Subject: FW: AB/120/20/PL and AB/ 121/20/L Old Bank House, 1 High Street, Arundel

Subject: AB/120/20/PL and AB/ 121/20/L Old Bank House, 1 High Street, Arundel

Title:-
Proposed Site Plan

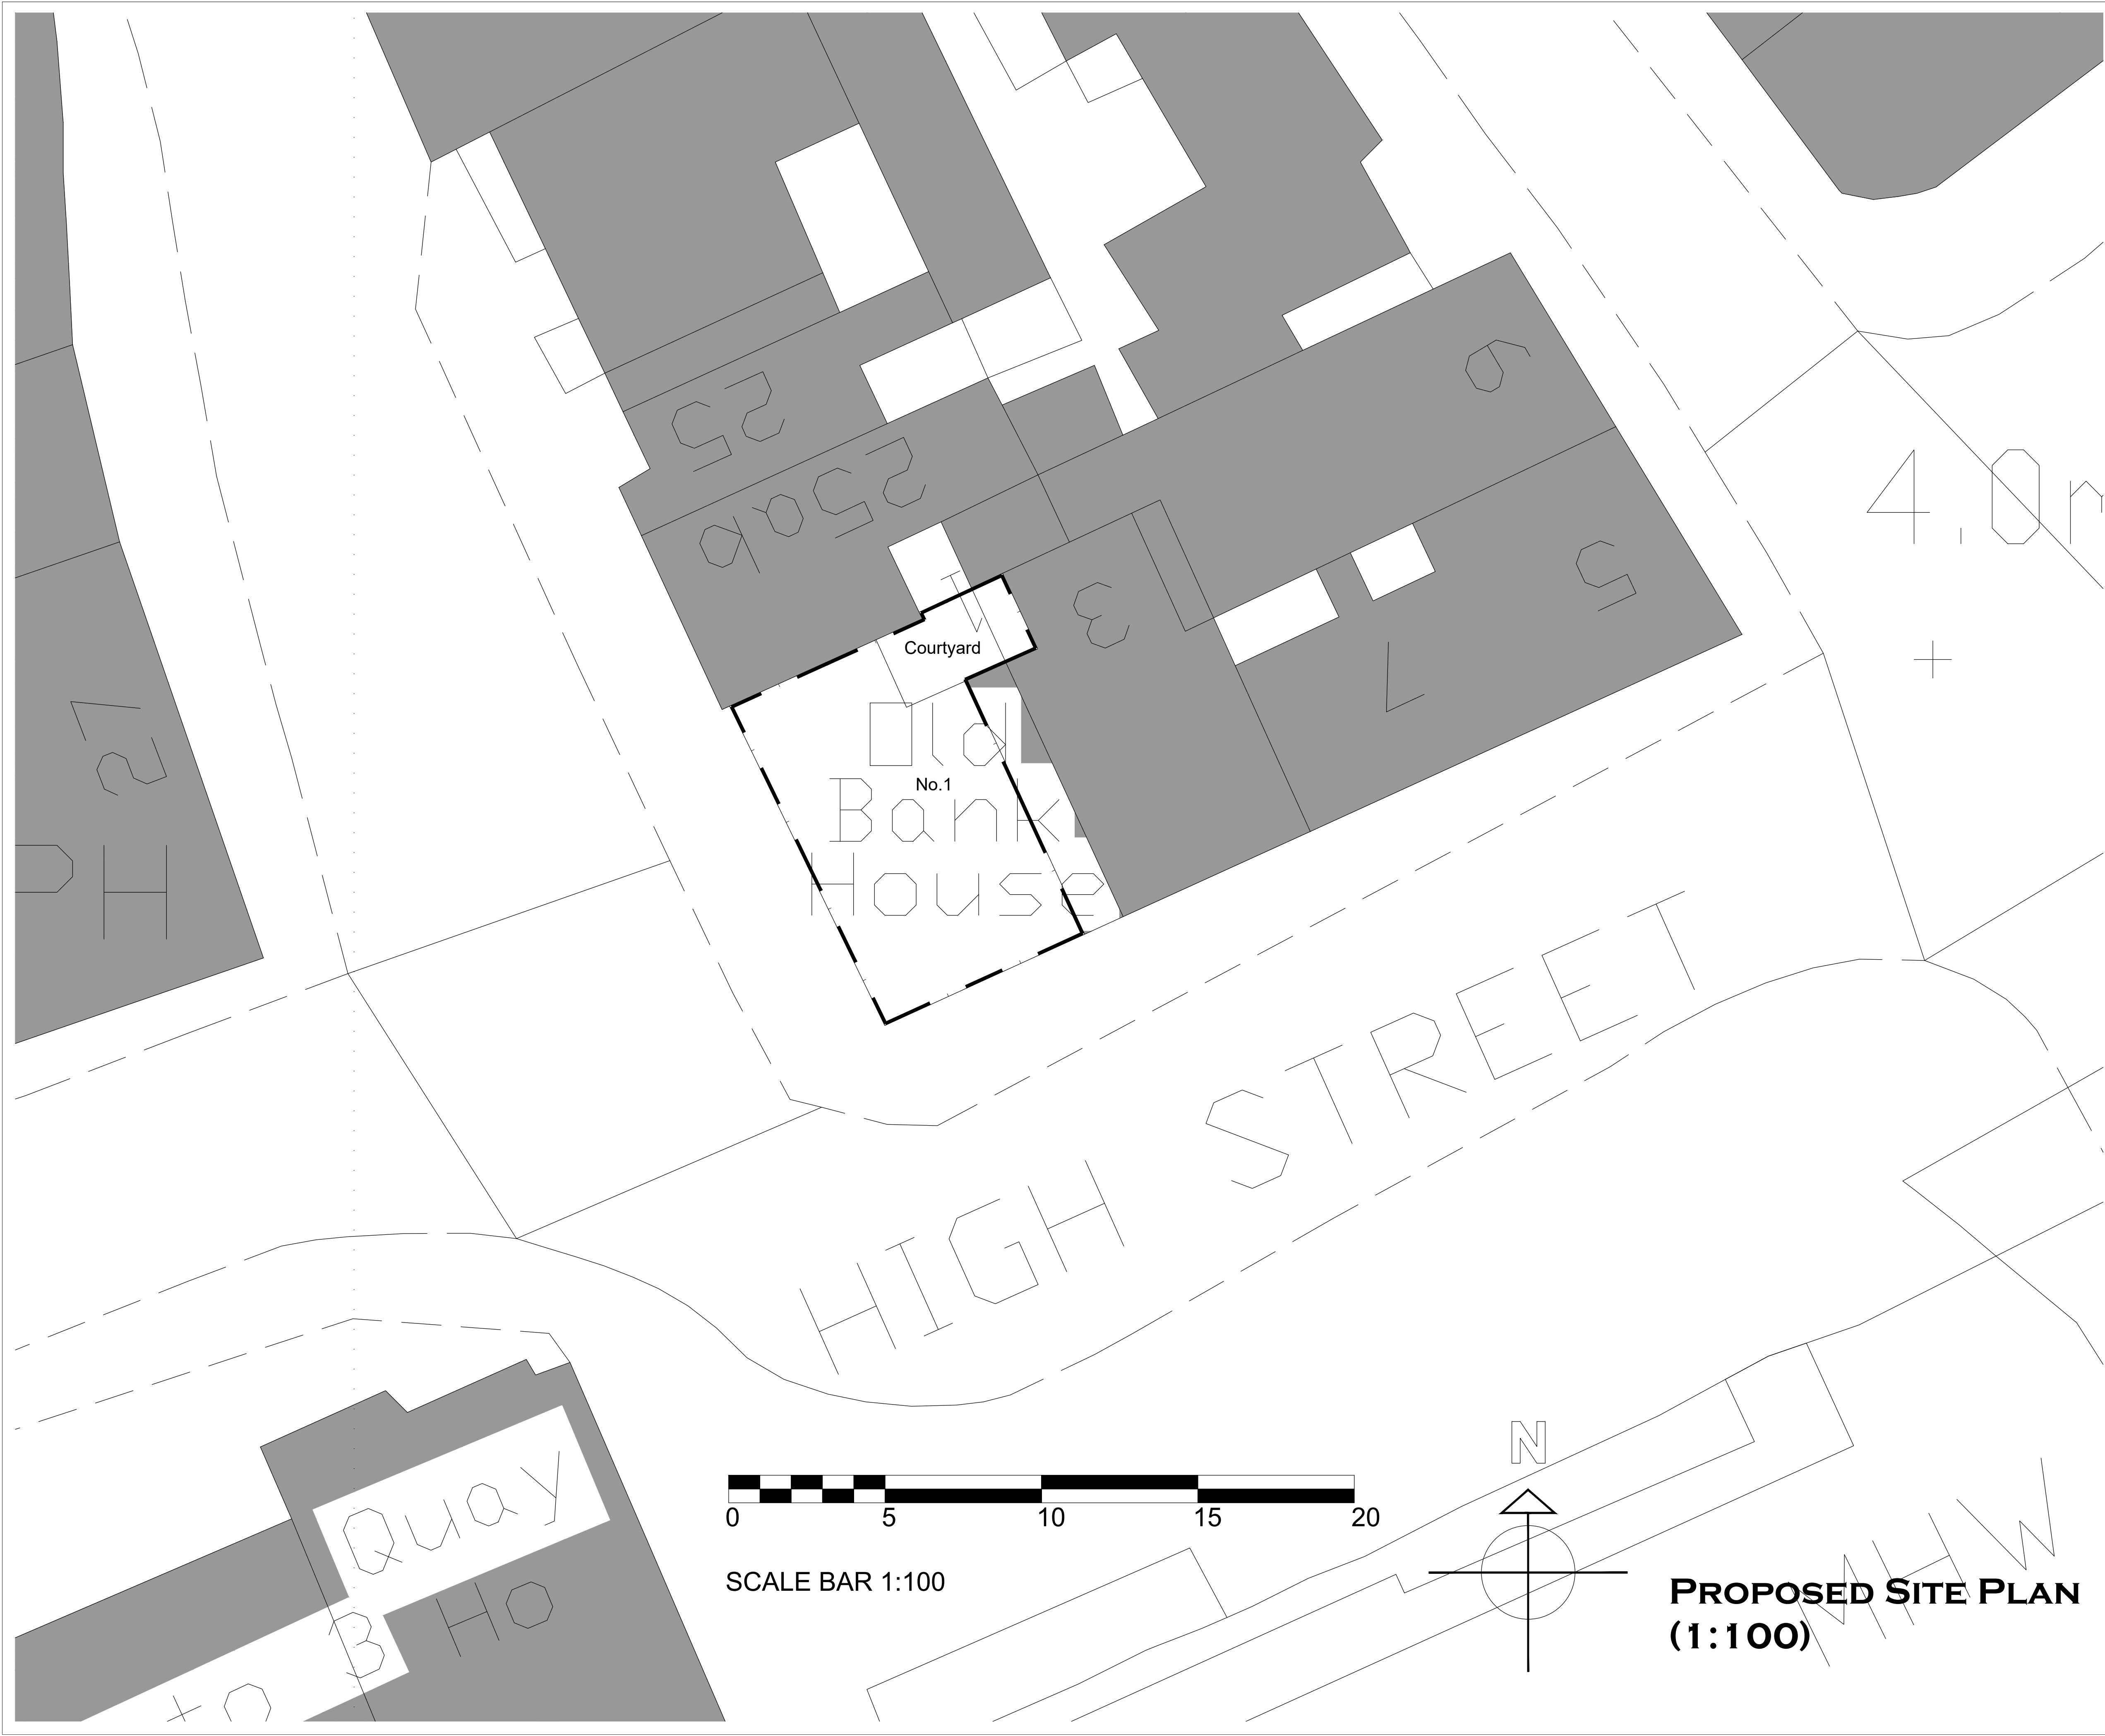
I have been looking at your applications with a view to writing my reports prior to the Christmas break, but I don't think it is going to be possible given the discrepancies in the location/block and floor plans. There is no plan clearly denoting the extent of the rear outside amenity area and the red edge of the application site to the rear of the premises does not appear to tally with the ground floor plan. The shape and projection to the rear do not appear to correlate. Please can you clarify and let me have revised as soon as possible.

Thanks for the email. I will look in to this and sort out a plan to show the outside area and check the boundaries on the site plans etc and amend as required. I probably wont be able to do this until the new year as I have finished for Christmas now. I might be able to look at over the Christmas break but can we agree to leave it until the new year and I will get drawings across to you. Happy to agree extension of time if required.
